Ms Jessie Evans
Director, Minerals & Quarry Assessments
Energy Resource Industry Assessments
12 Darcy St
PARRAMATTA NSW 2150

I refer to our previous advice regarding the Dendrobium Mine Extension Project (dated 14/6/2022, our reference DOC22/466886). We advised at that time that we had not been able to inspect the surface infrastructure and subsidence impact areas within the Catchment due to the excessive wet period preventing access. We were also awaiting internal clarity on the appropriate method for determining some species polygons. We have now undertaken a site inspection and progressed our position on determining species polygons. Our updated advice is provided below however in summary, the current BDAR is likely to result in an under-estimation of offset credit obligations.

Figure 3-4 Swamps Mapped within the Study Area.

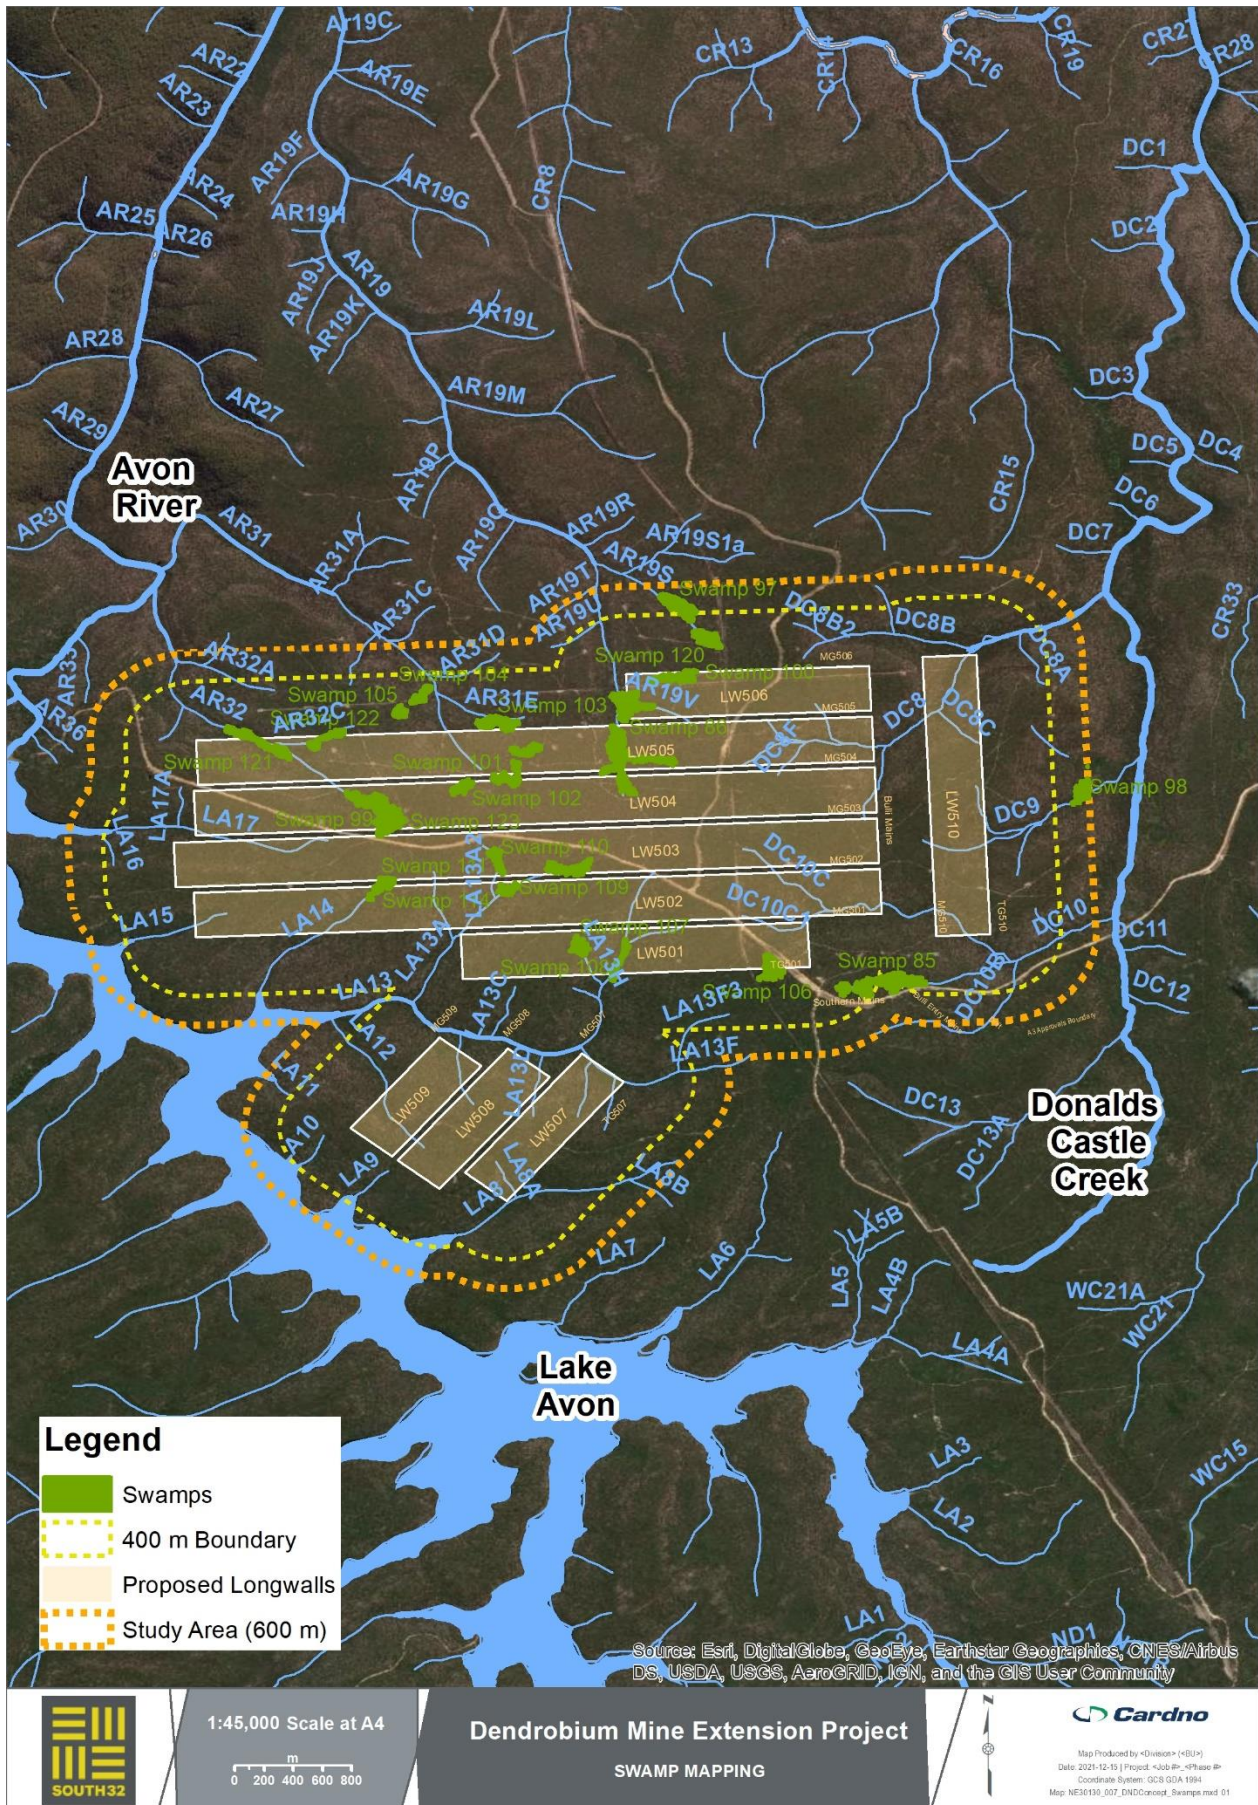
- Swamp mapping, as per Figure 9 in the BDAR and GIS Shapefile 6624_Coastal_Upland_Swamp_20220318.shp is an accurate representation of the extent of swamps for the purpose of impact assessment and offsetting under the Upland Swamps Offset Policy. As noted previously, the proponent should ensure that the threatened Coastal Upland Swamp community is mapped in accordance with the Final Determination. That is, mapping should consider that the tree-line does not necessarily define the swamp and scattered trees can occur within swamp boundaries. The issue also remains for the proponent to appropriately apply the Upland Swamps Offset Policy as per our previous correspondence.

- *Giant dragonfly*: The species polygon should include the whole of the mapped swamp, as per GIS Shapefile 6624_Coastal_Upland_Swamp_20220318.shp.
- We are also still waiting on a Giant Dragonfly Report which the proponent commissioned but did not include in the BDAR/EIS. This should be provided to BCD for review prior to finalisation of the BDAR.
